STERLING RANCH FILING NO. 5

GRADING AND EROSION CONTROL PLAN

DECEMBER 2023

SHEET 3 OF 7

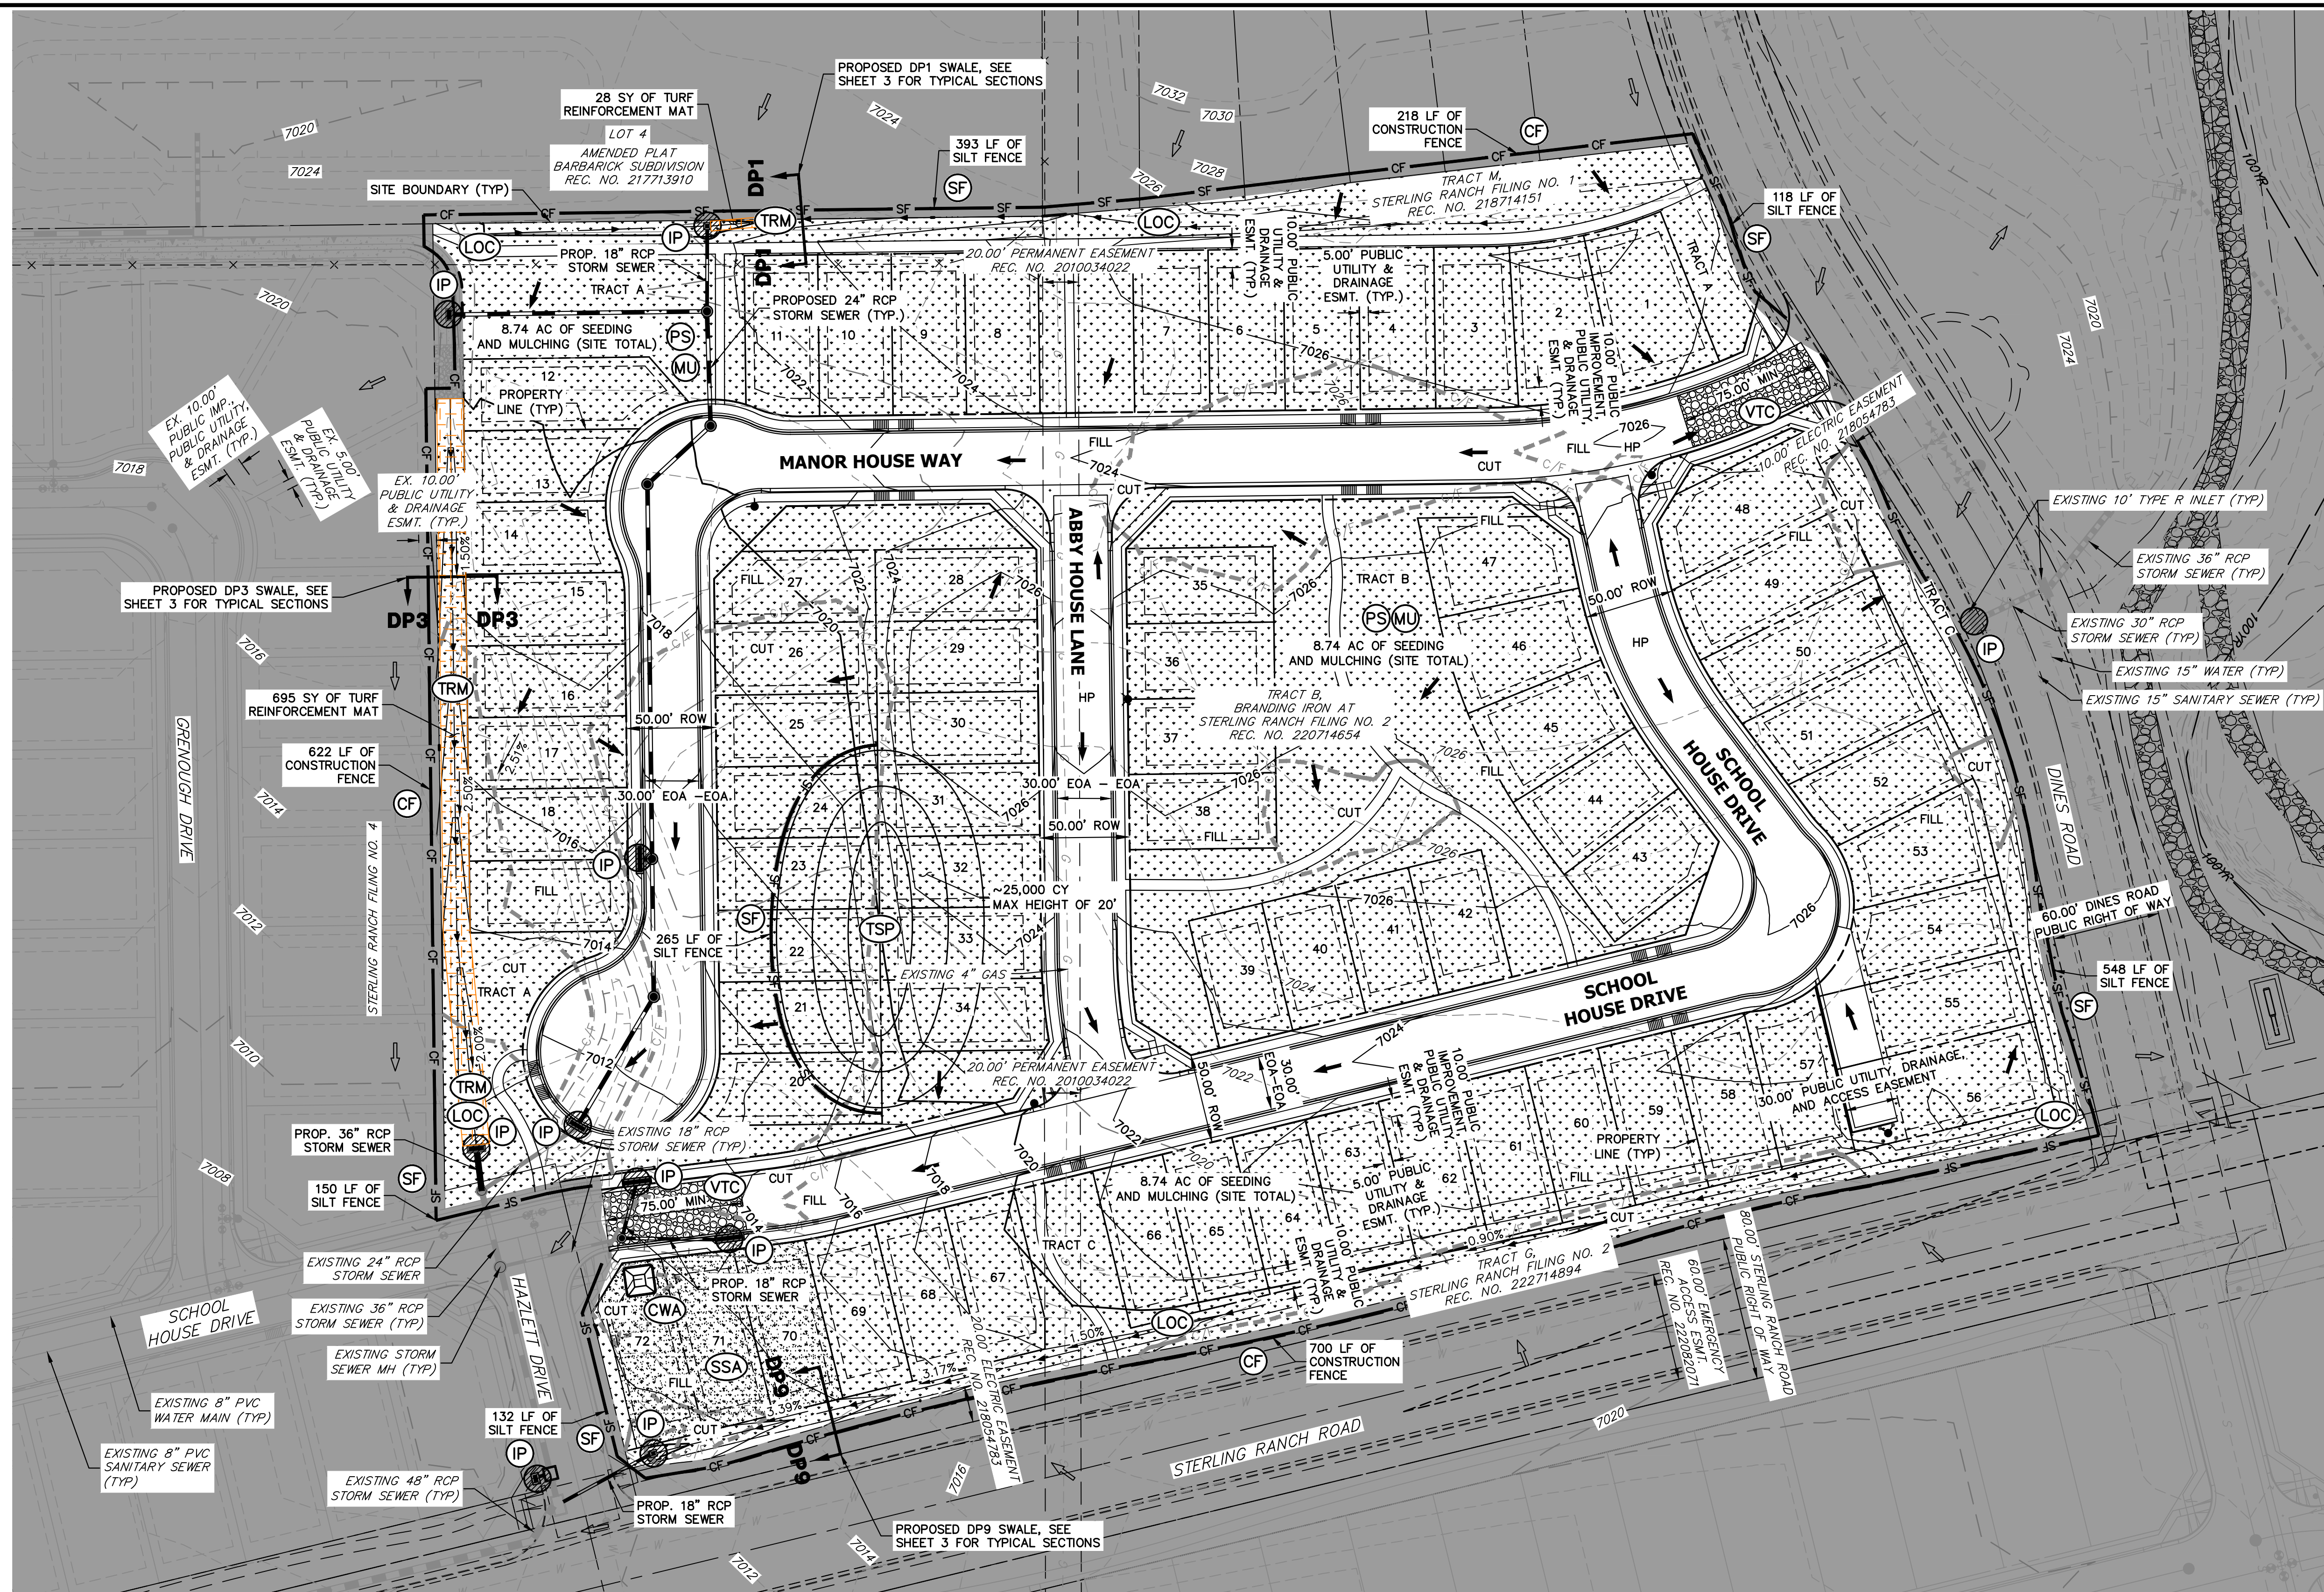
GEC Checklist Items H and M. If "limits of disturbance" and "construction boundary" are the same, change to "limits of construction/disturbance" or otherwise show as separate line types for each on the legend and figure.

Make a note addressing GEC Checklist Item "I"
